PLANNING CONSULTATION RESPONSE

Application No	2026/0234
Proposal	Erection of side extensions; raising of roof height to create first floor accommodation; erection of outbuilding to replace existing garage and formation of 2x new vehicular accesses.
Address	1 Newfield Avenue, Monk Bretton, Barnsley, S71 2LD
Date of Consultation Reply	30 th April 2026
Consultee	Highways DC

[2nd Response – Amended plans]

PROPOSED PLANS & ELEVATIONS

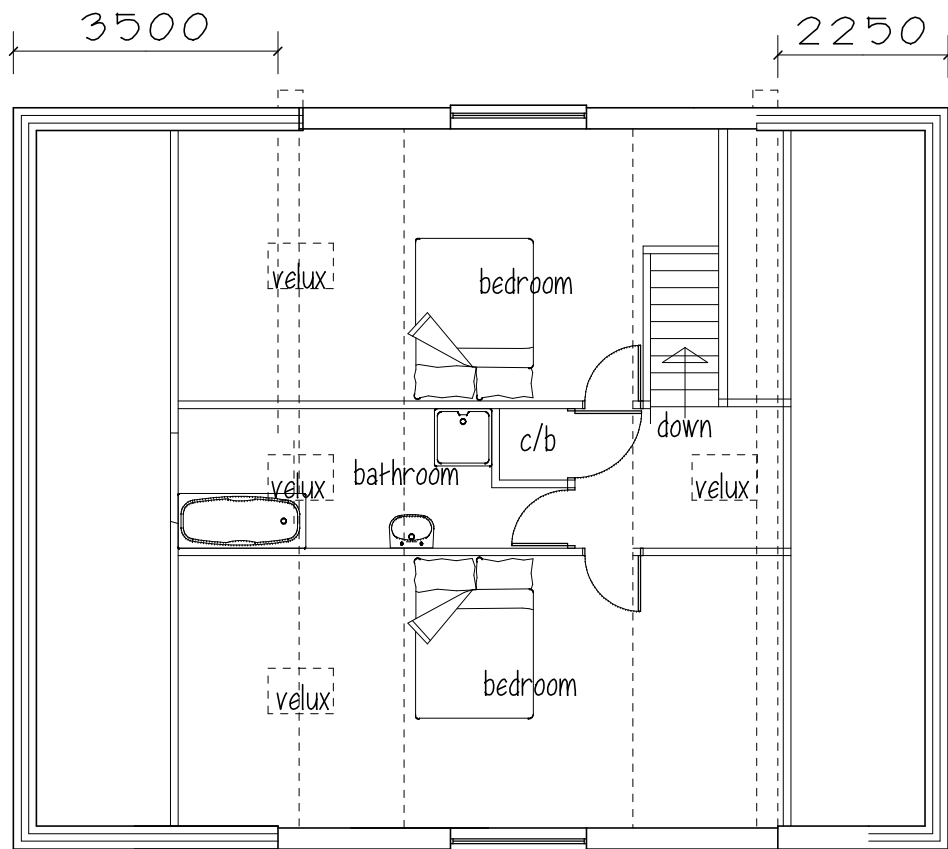
The proposals now include the creation of only one new vehicular access point, the existing access off Newfield Avenue is to be retained and will provide access to an integral garage.

The integral garage shall be fitted with a roller shutter type door and shall be permanently retained as such for the lifetime of the development.

1 NEWFIELD AVE.  
MONK BRETTON  
BARNSELY S71 2LD  
LOCATION & SITE PLAN 1:1250, 1:500@A4 Rev D

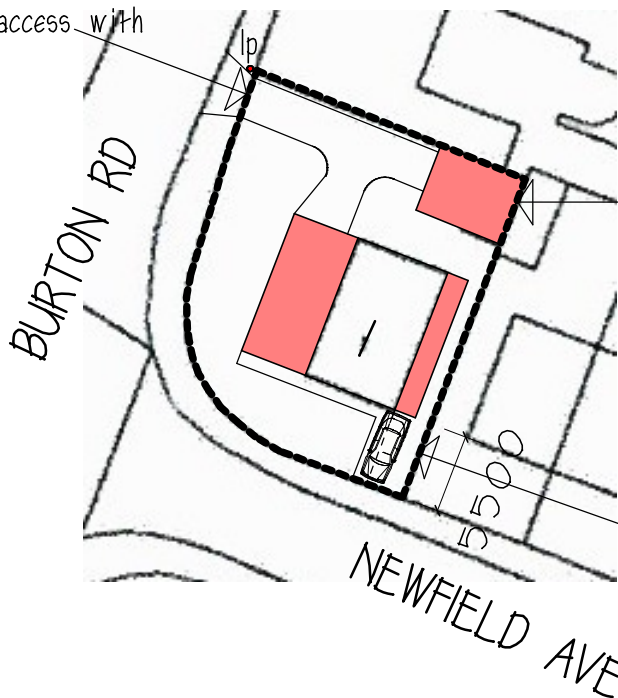
The proposed new access off Burton Road has been slightly repositioned to avoid access/egress being impeded by the lighting column. The layout plan now shows that an internal turning facility is to be provided; it is noted that the turning area is small and would likely require a back-and-forth shunting manoeuvre, nevertheless, a vehicle would be able to turn within the site.

In view of the above, the proposals are considered acceptable from a highways development control perspective subject to the conditions and informative notes listed below, which I would be grateful if you could include if you are minded to grant permission.
